WELWYN HATFIELD COUNCIL – DEVELOPMENT CONTROL
DELEGATED REPORT

APPLICATION No:	S6/2011/1709/FP
------------------------	------------------------

The proposal seeks planning permission for the creation of a new vehicular access point to the far south eastern point of the application site. New brick piers measuring a maximum 2m in height along with electric opening gates measuring a maximum 2.2m in height are proposed.

Drq.No: AT355-20

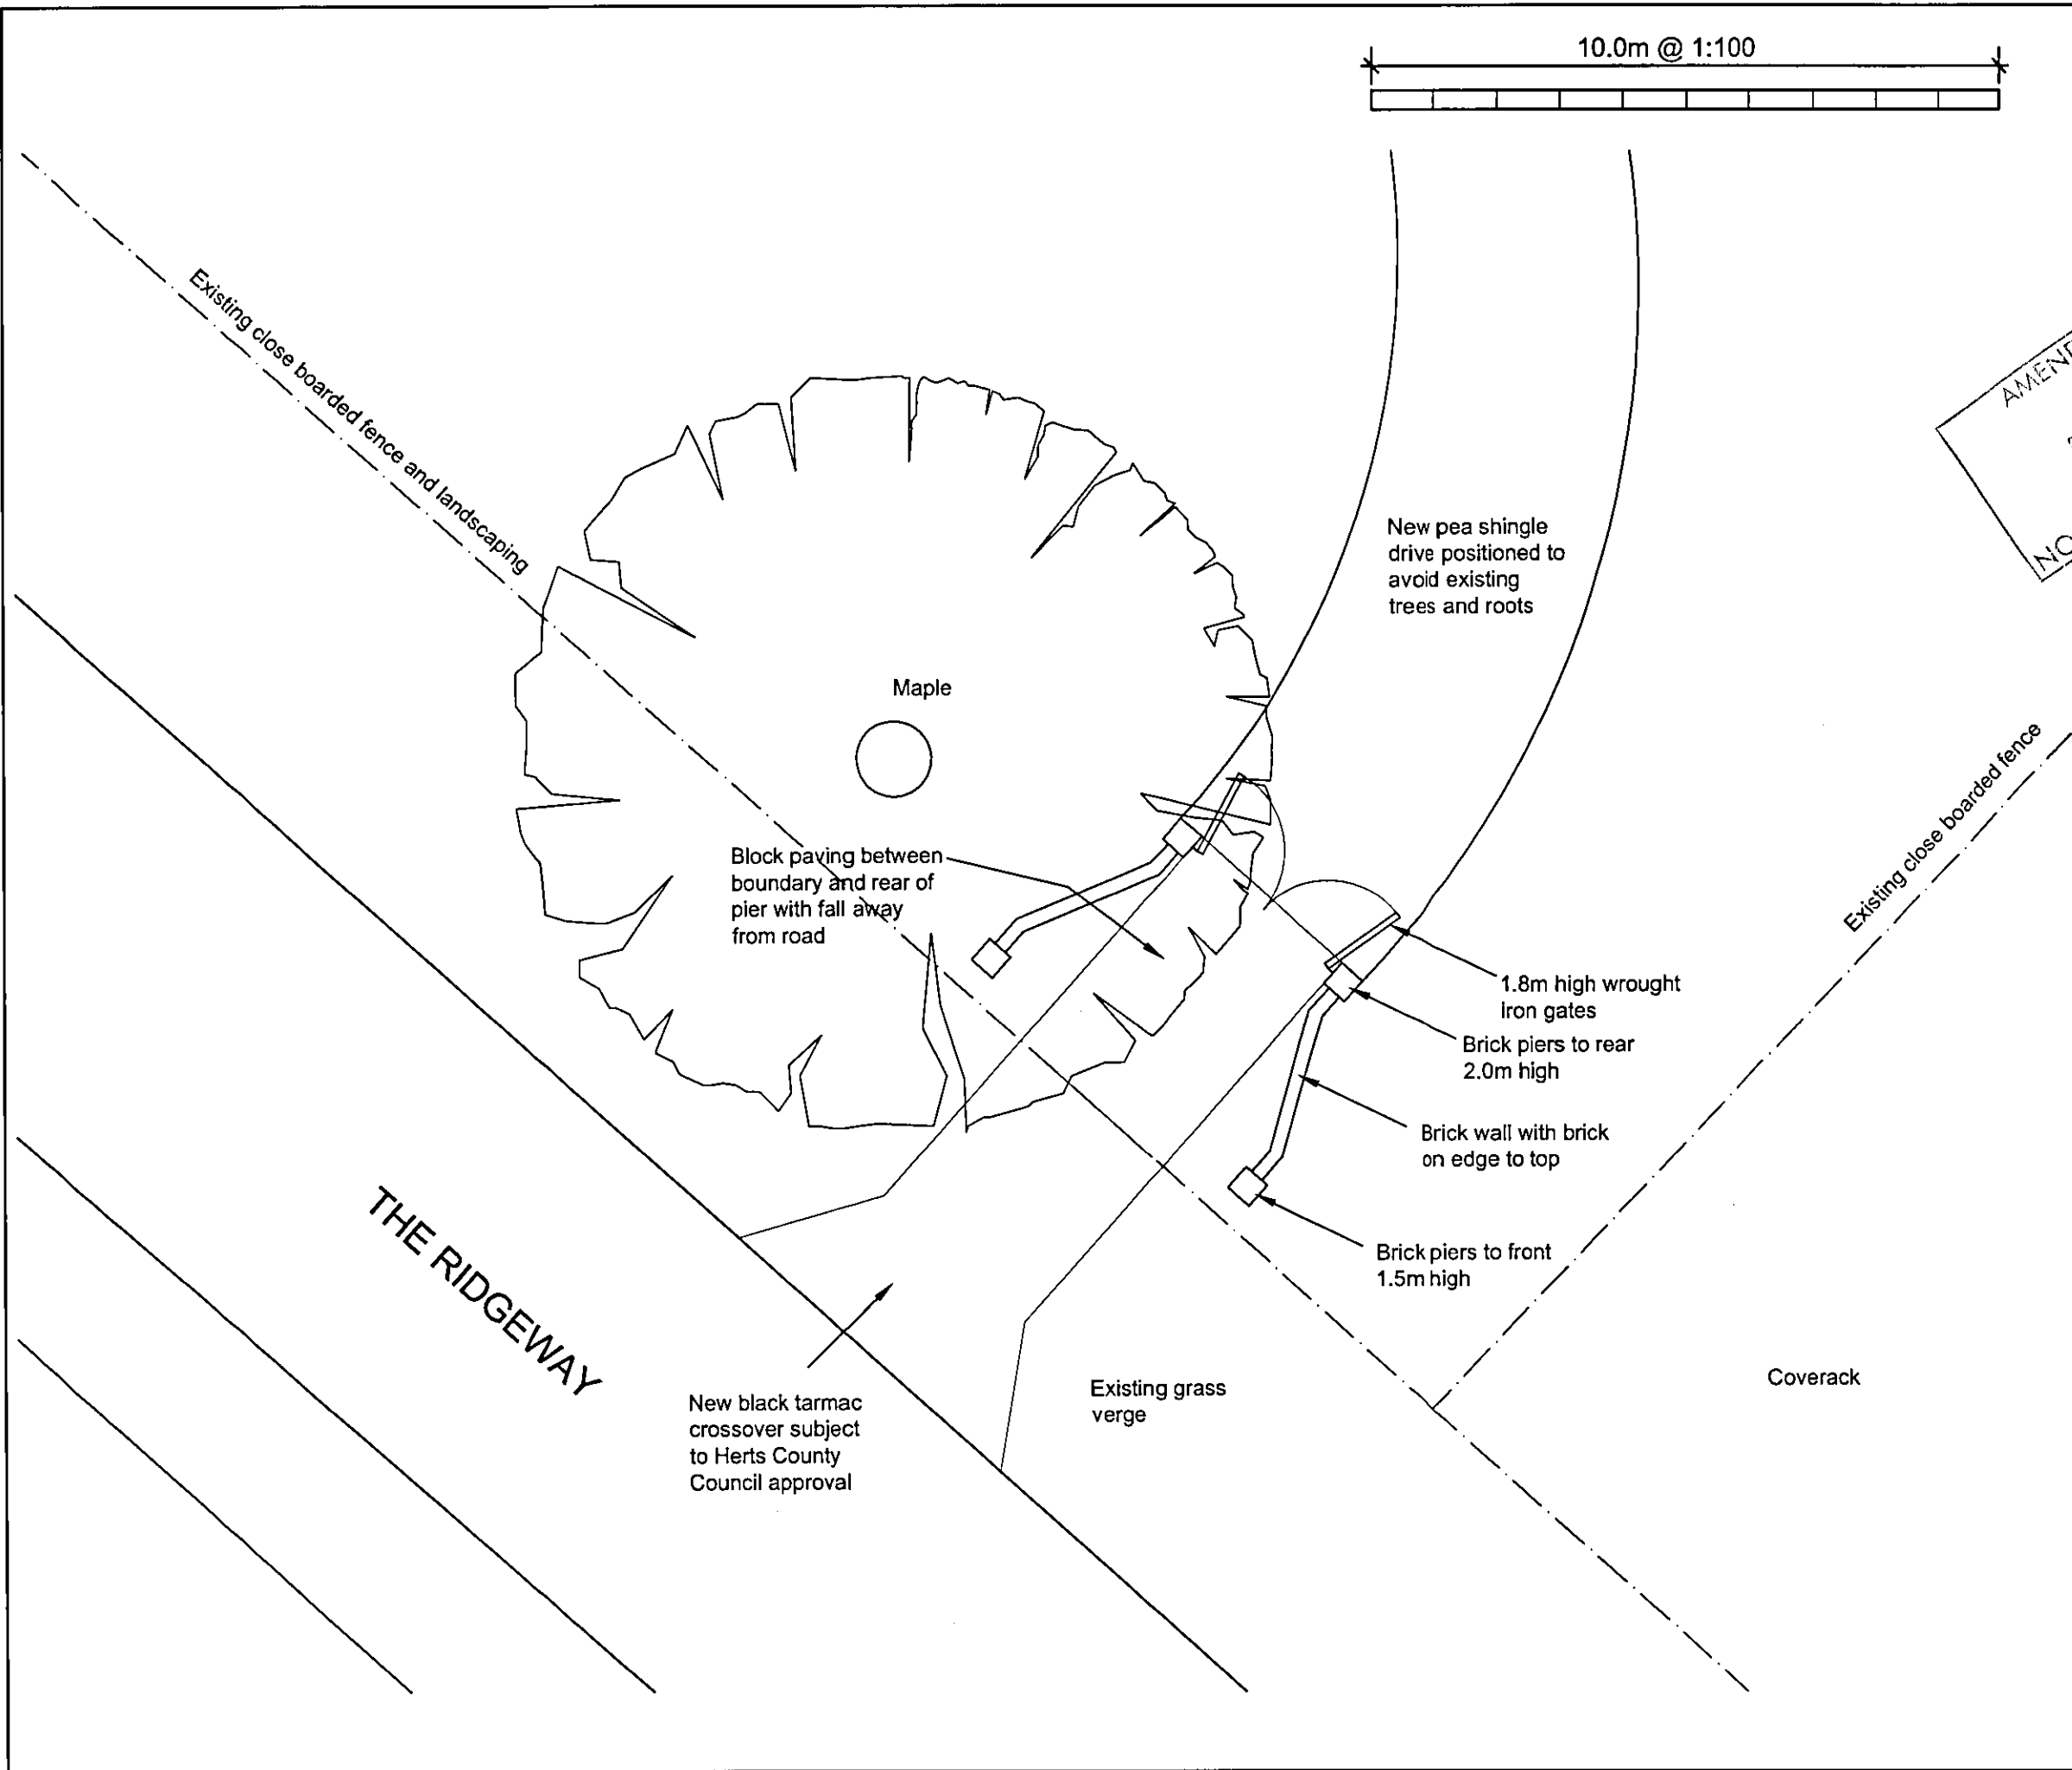
Hertfordshire Highways: The highway authority would have no reason to object to the relocation of this access. The proposed access is better sited than the existing and visibility splays of 2.4m x 90m can be provided within the existing highway verge. The gates are set 6m back from the edge of the carriageway.

The highway boundary is the fence line and I understand there is a highway drain in this highway verge that has recently been filled in by the property owner, without the permission of the highway authority. Once this drain has been reinstated, it may be culverted where it passes under the new vehicle crossover and the developer would be liable for the cost of these works.

8. The gates should be located as shown on drawing number AT355-20 and shall open inwards into the site.

Dwg.No: AT355-21

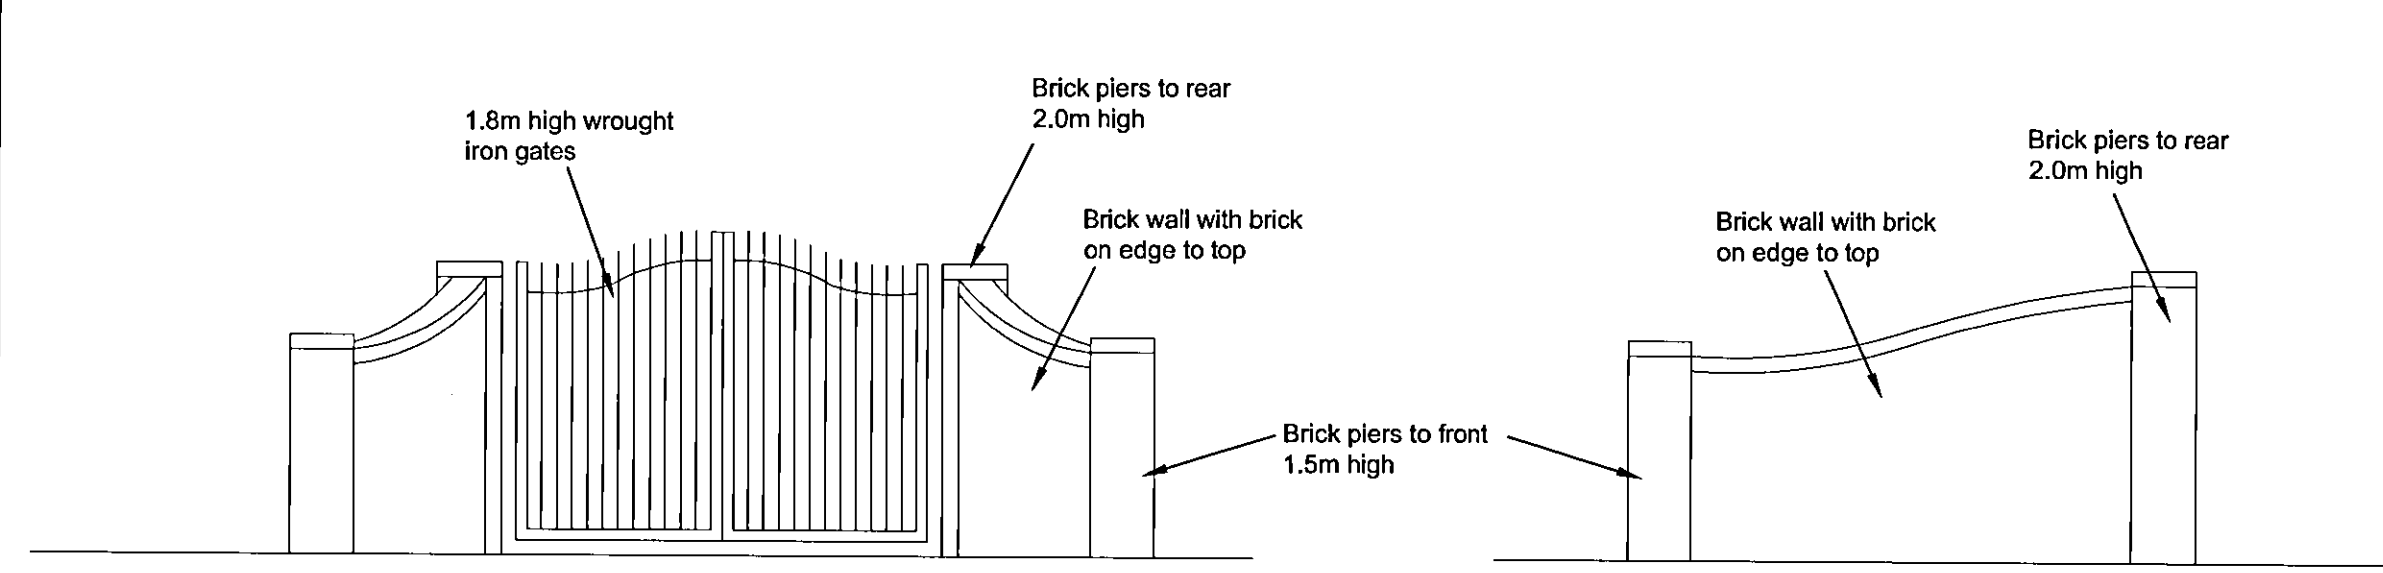
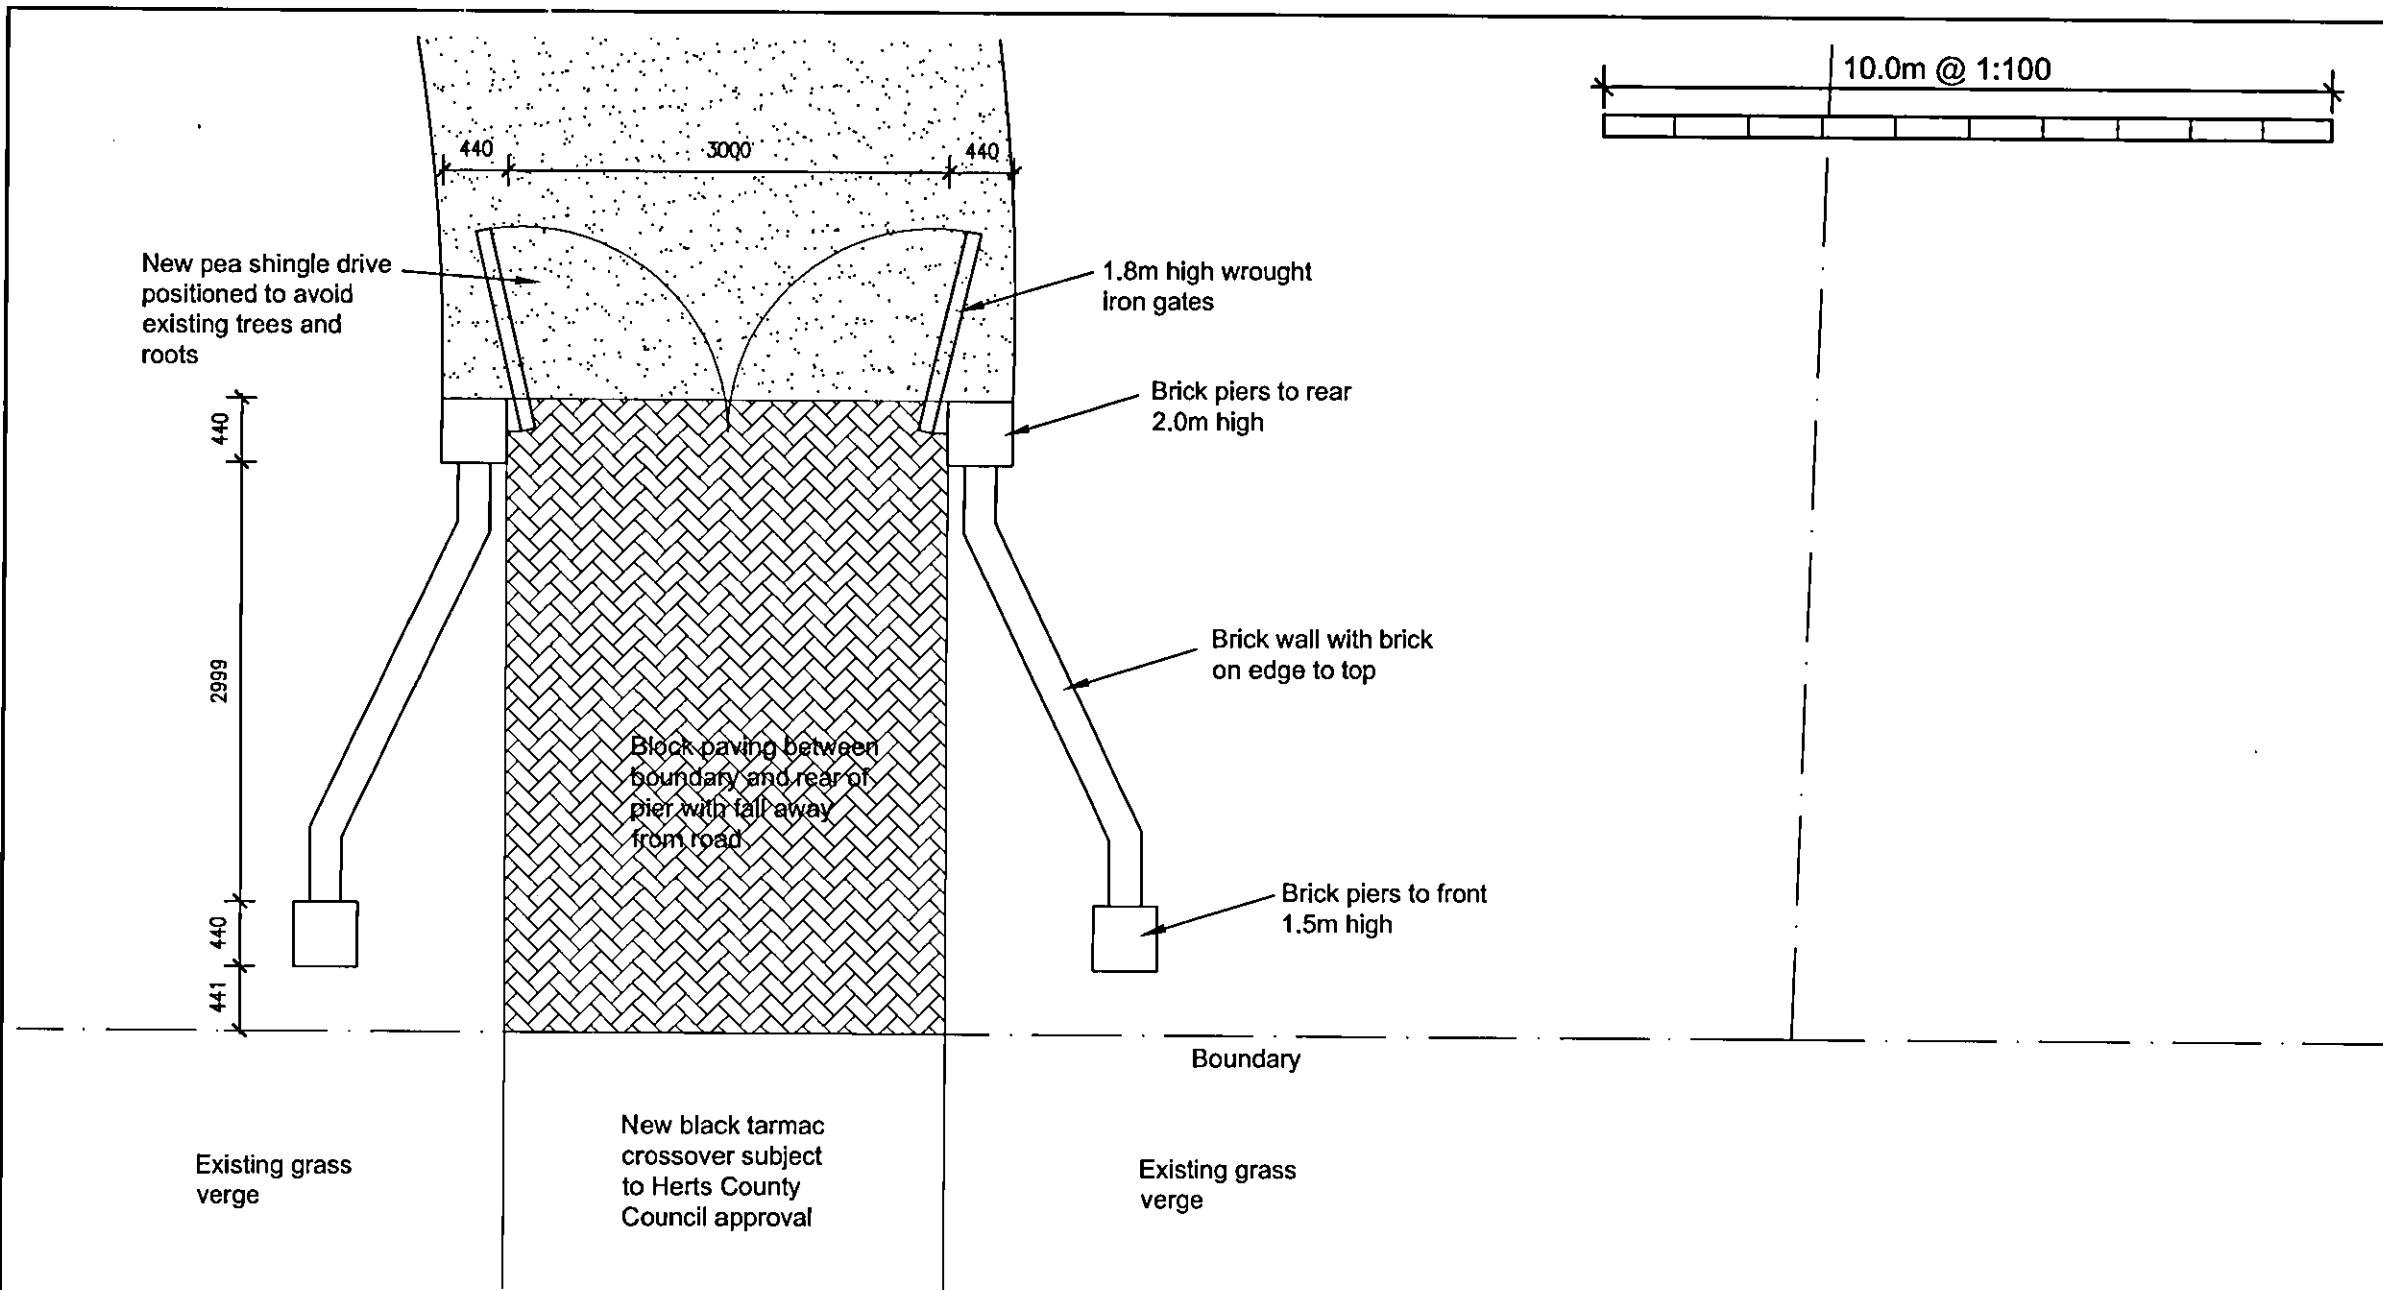
In regards to criteria (ii), the character of this part of The Ridgeway comprises mainly of large hedgerows combined with gates and brick pier entrances. The proposed gates are open railings, provided only as an entrance gate and not across the whole frontage of the site. The proposed brick piers will be set back approximately 6m from the highway. In addition, the existing mature landscaping to the front of the site would be retained and whilst landscaping does not make an unacceptable development acceptable, it minimises the whole visual impact. It is considered that the proposal will be acceptable in Green Belt policy terms of PPG2 and will also meet the requirements of local plan policy RA3 (which reflects PPG2) as the resultant visual impact will be acceptable.

In regards to policy D1, the design of the gates are considered to be acceptable. The exact details on the materials to be used in the proposal are unknown however a planning condition should be attached to approve the materials. In addition, the landscaping details relating to the stopping up of the existing access on the corner of The Ridgeway/Carbone Hill is subject of a condition.

4. No development shall take place until details of the materials to be used in the construction of the new vehicular entrance, including brick piers, gates and block paving hereby permitted have been submitted to and approved in writing by the Local Planning Authority. The development shall be implemented using the approved materials and subsequently, the approved materials shall not be changed without the prior written consent of the Local Planning Authority.
